Group submission relating to application SSD 5878

Sydney International Convention, Exhibition and Entertainment Centre Precinct – Mixed use Development in the Southern Haymarket Precinct (Concept Proposal) (SSD)

We are local residents, living in Haymarket and though we consider the whole development proposal to be ill conceived and not in the best interest of either Sydney's residents or its visitors, our particular concern is the Southern Haymarket Precinct proposal.

DEVELOPMENT APPLICATION
PEAK TOWER - NORTH ELEVATION
PROPOSED BUILDING PROFILE OVERLAY

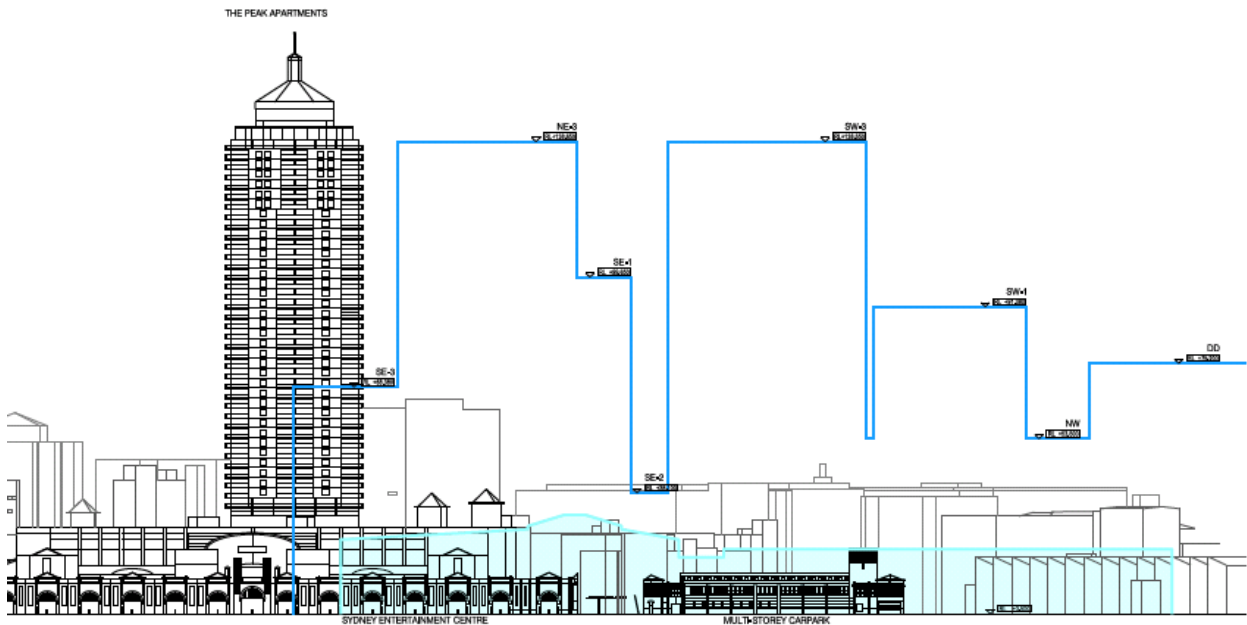
This shows these planning guidelines have been ignored in the drive for increased density and optimum placement of the new towers for maximum return - all with scant regard for the existing buildings.

The loss of amenities, outlook and views is an excessive burden on the residents of the Peak and for all the residents of surrounding buildings. At a minimum, it is imperative to delete the Tower SE1 from the planned development.

The following figure – buried in SSD 5755 illustrates the size of the proposal in relation to The Peak.
